Applicant: Mr R Bratt

Proposal: Erection of garage adjacent to approved dwelling and change of use of land to residential

DRAWING NUMBER:
4728/21D

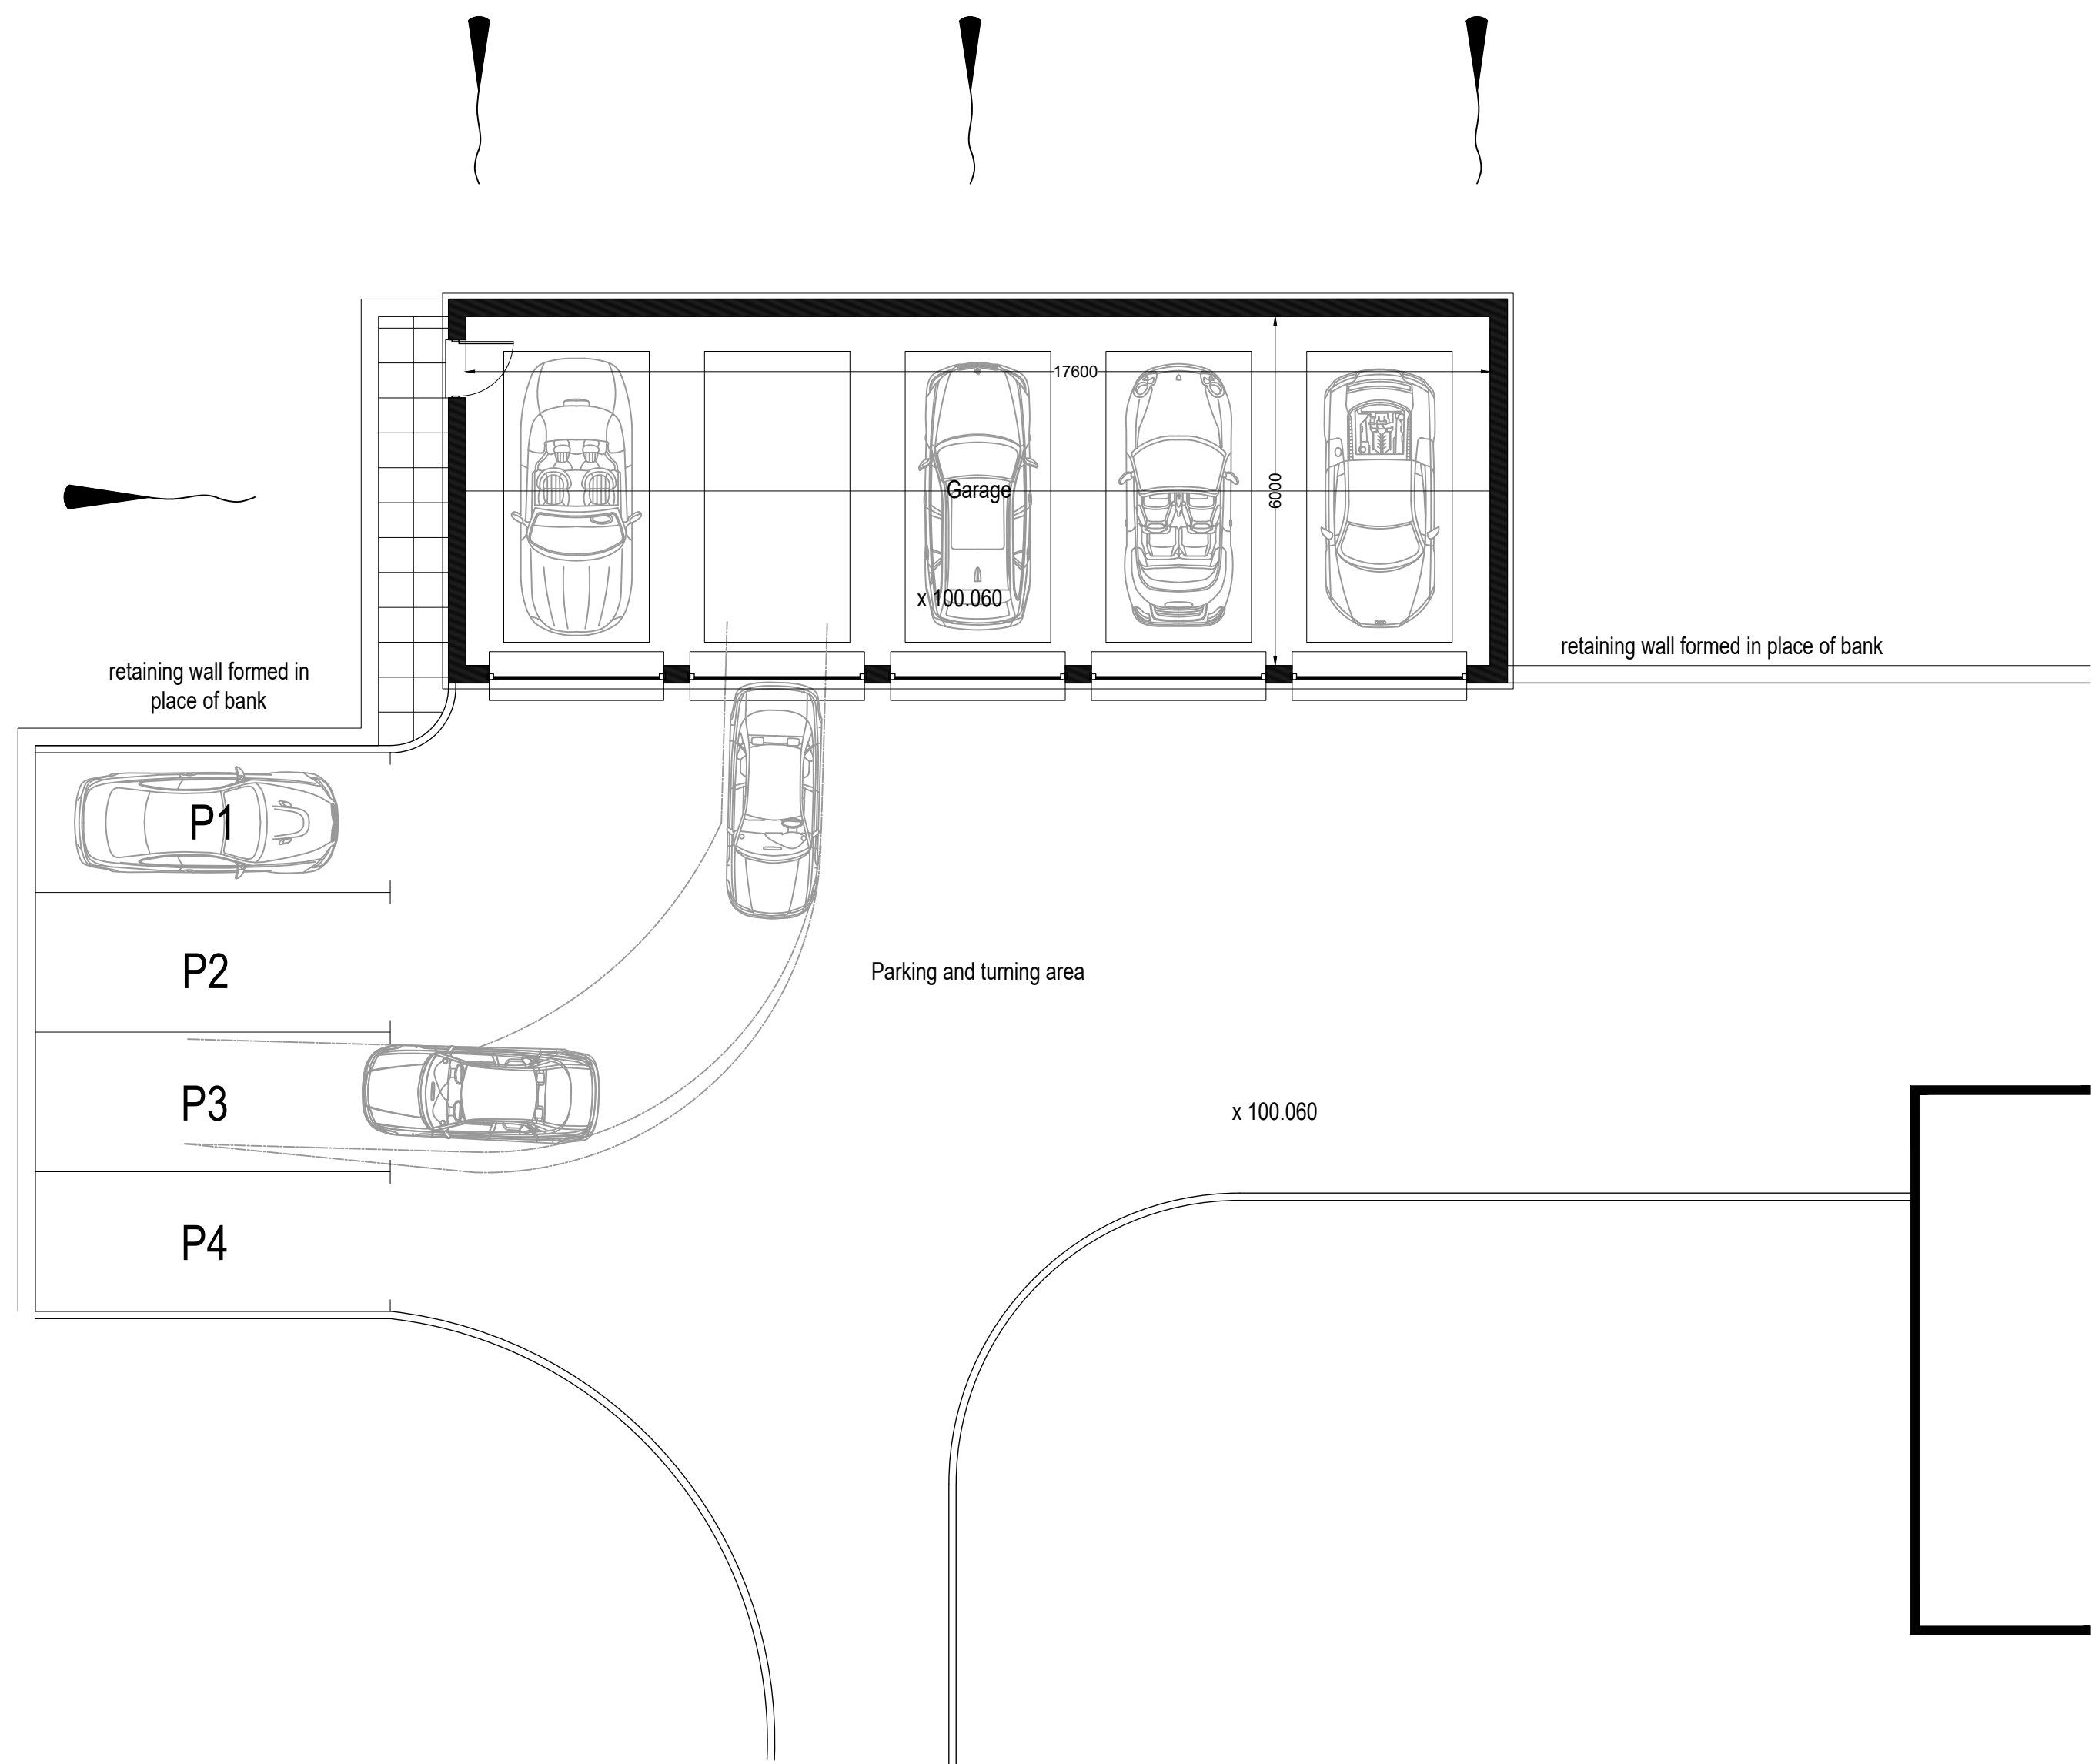
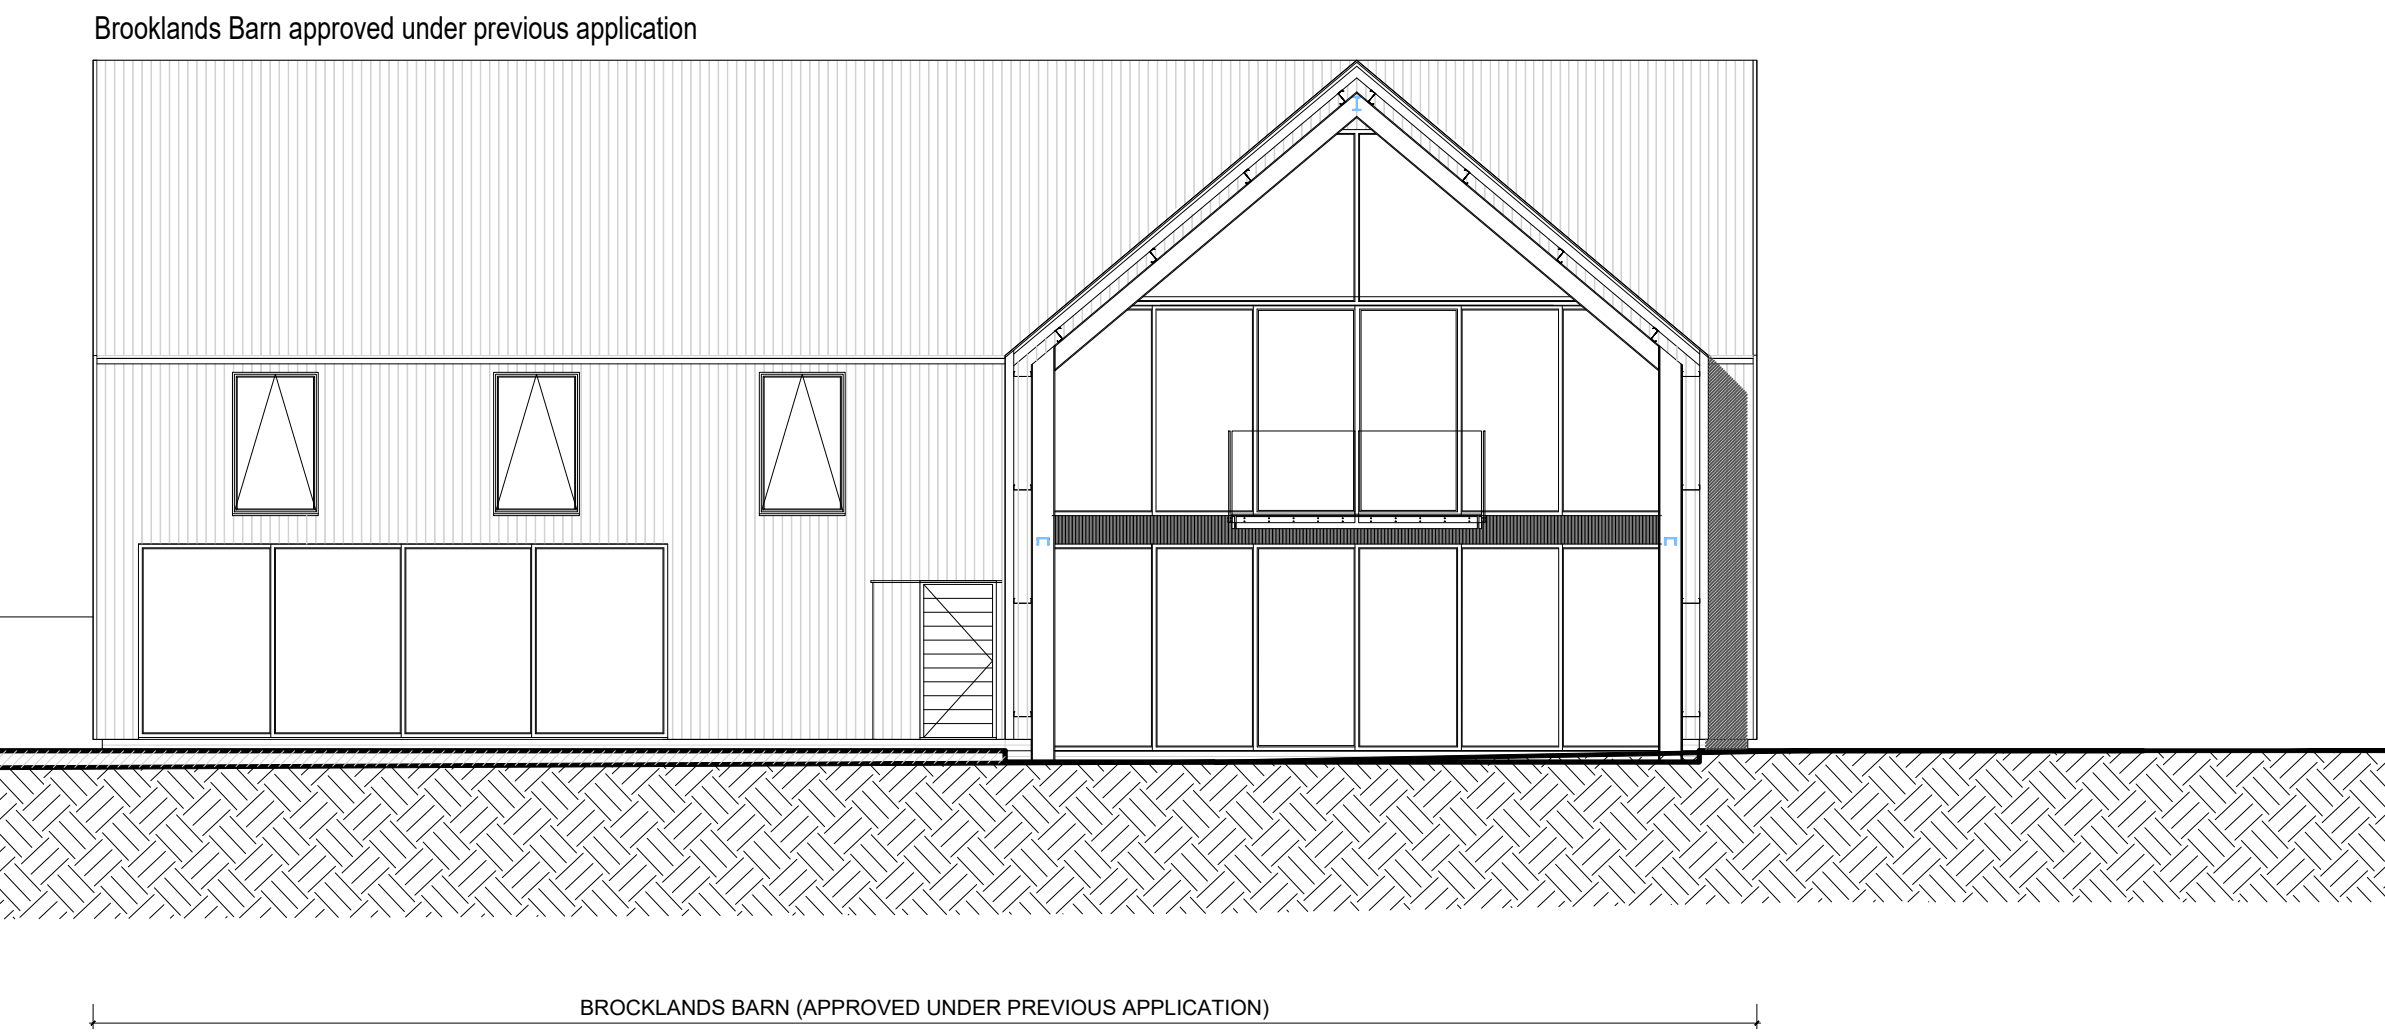
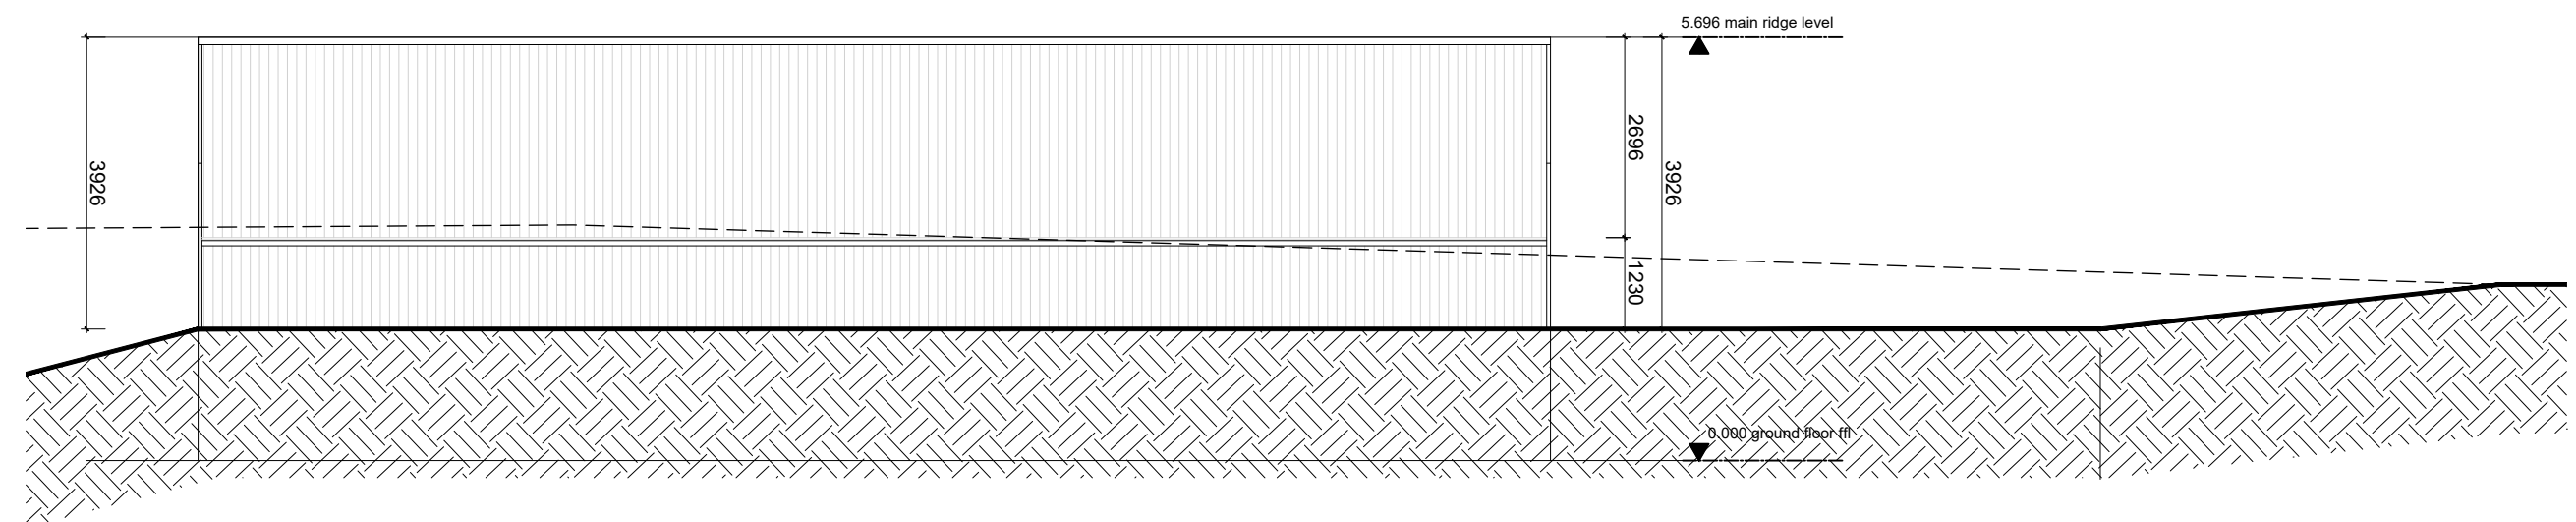
- 8.6. As noted above the proposed garage building is substantially larger than what might be considered a typical domestic garage. The proposed structure would be sited to the north-west of the on-going development at the site and in officer's opinion is poorly related to the main dwelling, appearing somewhat divorced. Whilst materials are proposed to match those proposed on the main dwelling, the overall appearance of the building would appear somewhat more commercial than a residential garage; largely due to the number of bays proposed.

- 8.7. The proposed building, notwithstanding the setting into the landscape, given its siting and scale would be visible within the landscape and would significantly increase the built form at this location. The extent of the proposed hardstanding, again poorly related to the main dwelling, further exacerbates the harm that would be caused by what is a substantial increase in the area of residential use at the site.

1. By virtue of its siting, scale and design the proposed substantial garage building and associated hardstanding, and by virtue of its extent and location the proposed change of use, are not considered sympathetic to the rural context of the site and are considered an inappropriate form of development, that would cause undue and unjustified visual intrusion into the valued rural landscape and open countryside. Further that it has not been demonstrated the proposals would provide a net gain in biodiversity opportunities at the site. The proposals are therefore contrary to the provisions and aims of saved Policy C28 of the CLP 1996, Policies ESD 10, ESD 13 and ESD 15 of the CLP 2031 and Government guidance within the NPPF in respect of conserving and enhancing the natural environment.
